Principal Areas of Disagreement Summary Statement (PADSS) from Surrey County Council - Version Number: ~~TwoThree~~ Submitted at: Deadline ~~TwoFive~~ - 26th ~~March-June~~ 20234

Figure 1: Location of Contractor Compounds

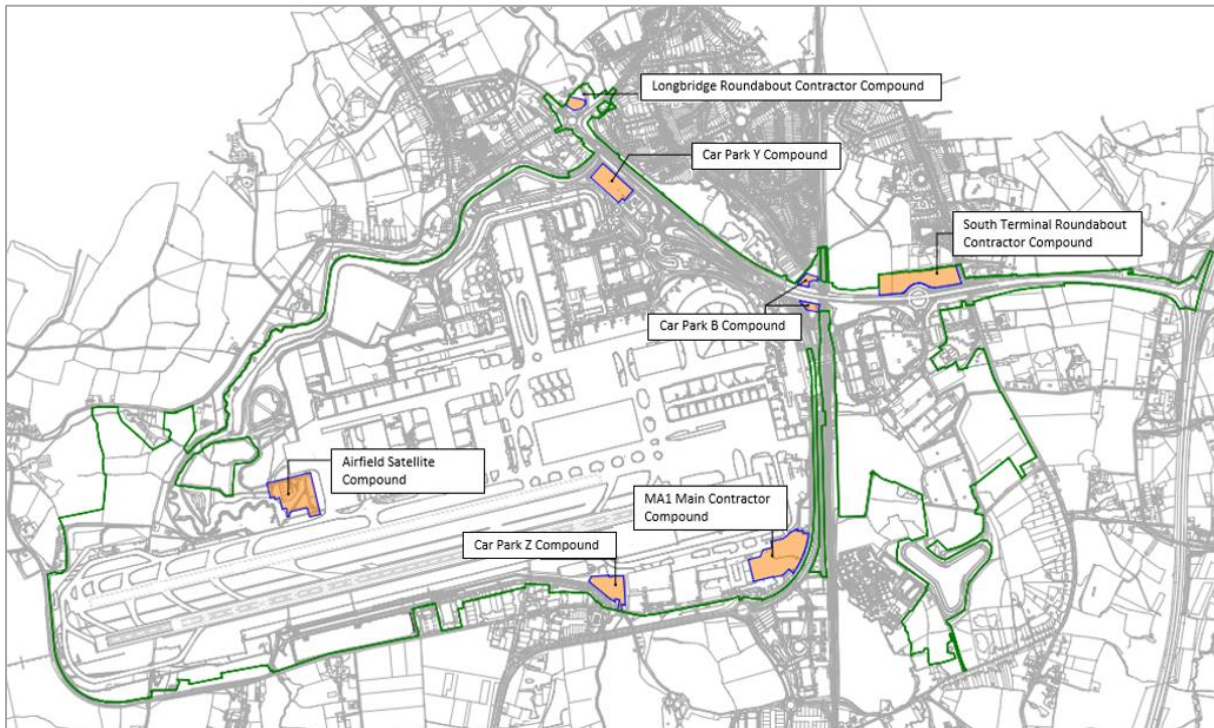
2122	Securing mitigation	The entrance to the Longbridge Roundabout compound is not defined.	SCC seeks confirmation of this requests that further information is provided for the	Likely

Ref	Principal Issue in Question	Concern held	What needs to change/be amended/be included in order to satisfactorily address the concern	Likelihood of concern being addressed during Examination
			Longbridge construction compound. The existing access is considered inappropriate as detailed in the LIR.	
2223	Securing mitigation	SCC is concerned that separate entrances to the South Terminal compound are proposed for HGVs (from the roundabout) and private vehicles (from Balcombe Road). This implies that an extended journey on the local road network is required.	SCC wishes to see all access to the South Terminal compound from the South Terminal Roundabout. Additional detail is sought during the examination.	Uncertain
Drainage and impact on Lead Local Flood Authority				
23	Clarity required around climate change allowances used in relation to the water environment	Only contains details of fluvial climate change allowance. Surrey County Council design guidance recommends using the Upper End rather than Central when determining climate change allowances.	Pluvial climate change allowances should be included, or if none being applied. Rationale required. Further detail has been provided in GAL's SoCG response. No further comment.	Likely Addressed
